**HELIOS** RENEWABLE  
ENERGY  
PROJECT

## **Environmental Statement Appendix 2.2: Scoping Opinion**

# **SCOPING OPINION:**

## Proposed Helios Renewable Energy Project

Environmental Statement Figure 6.1: Heritage Assets Considered within the ES

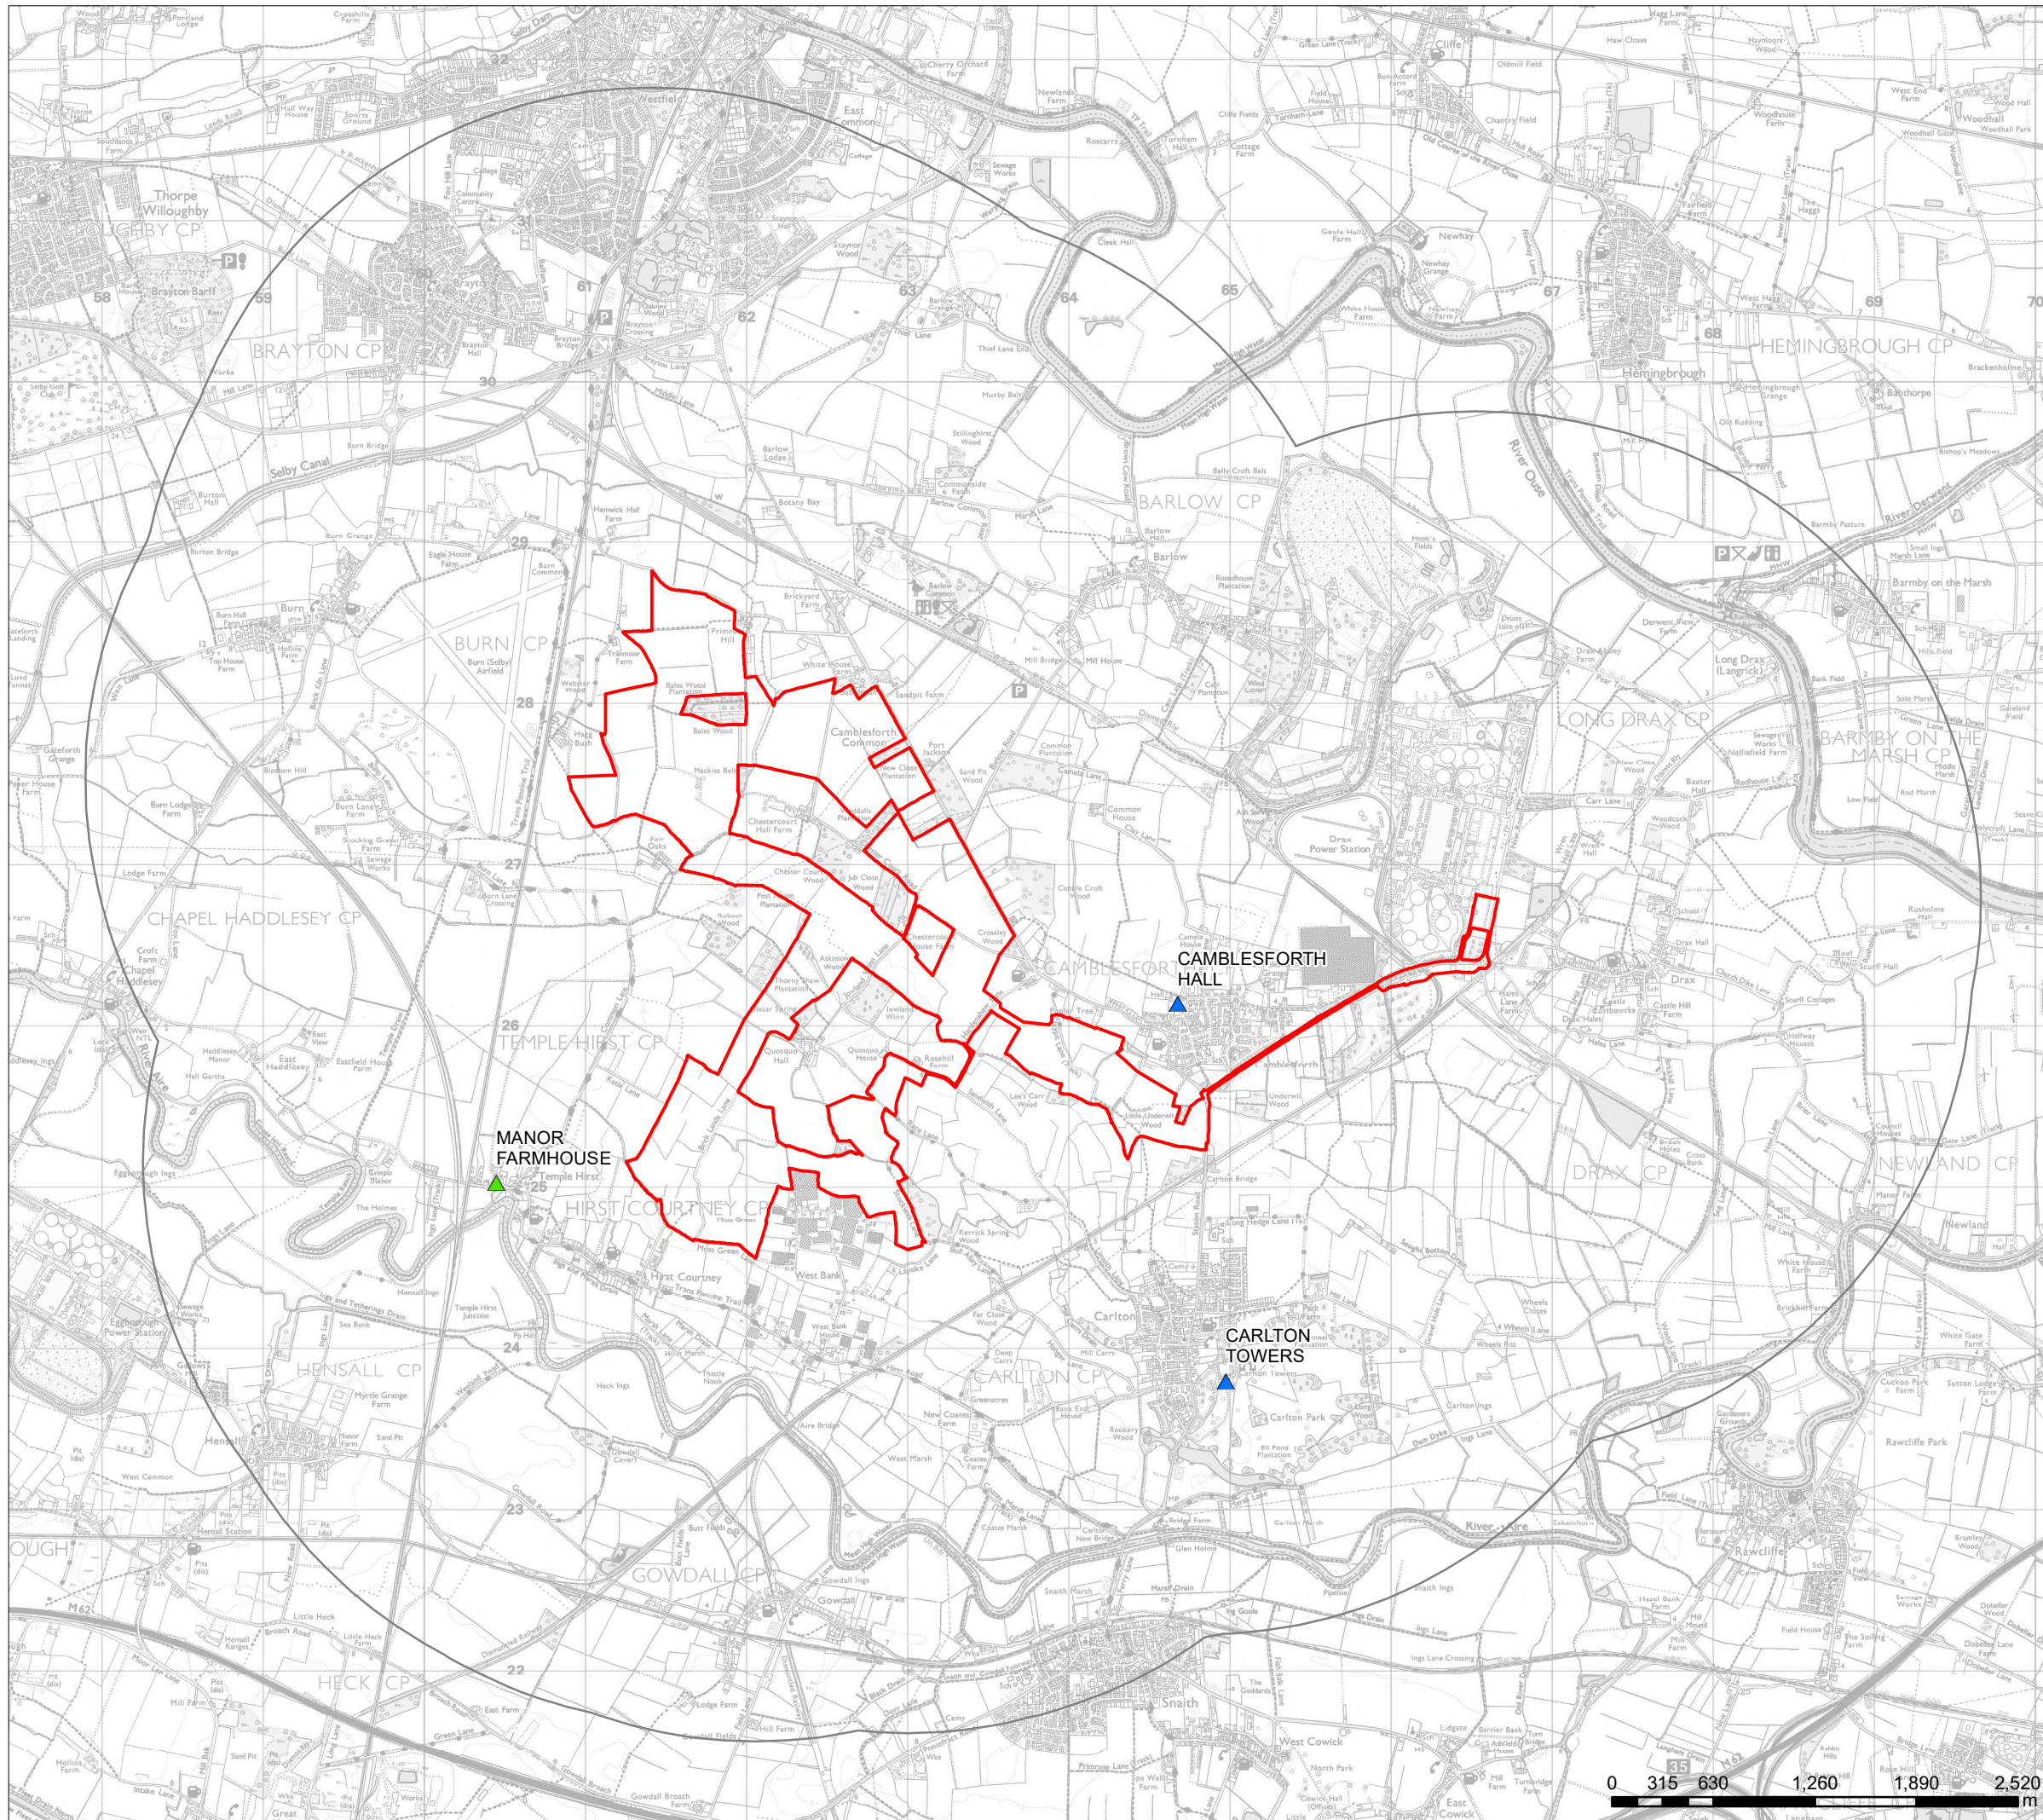
3.2.4	Table 6.1	Effects on Listed Buildings within the study area, excluding Grade I Listed Camblesforth Hall and Carlton Towers and Grade II listed Manor Farmhouse	<p>The Inspectorate does not agree to scope out impacts to listed buildings as some are located within the worst-case 3km study area (Figure 6.2) and no justification is provided for scoping them out.</p> <p>The ES should assess both direct and indirect impacts to listed buildings where significant effects are likely to occur.</p>
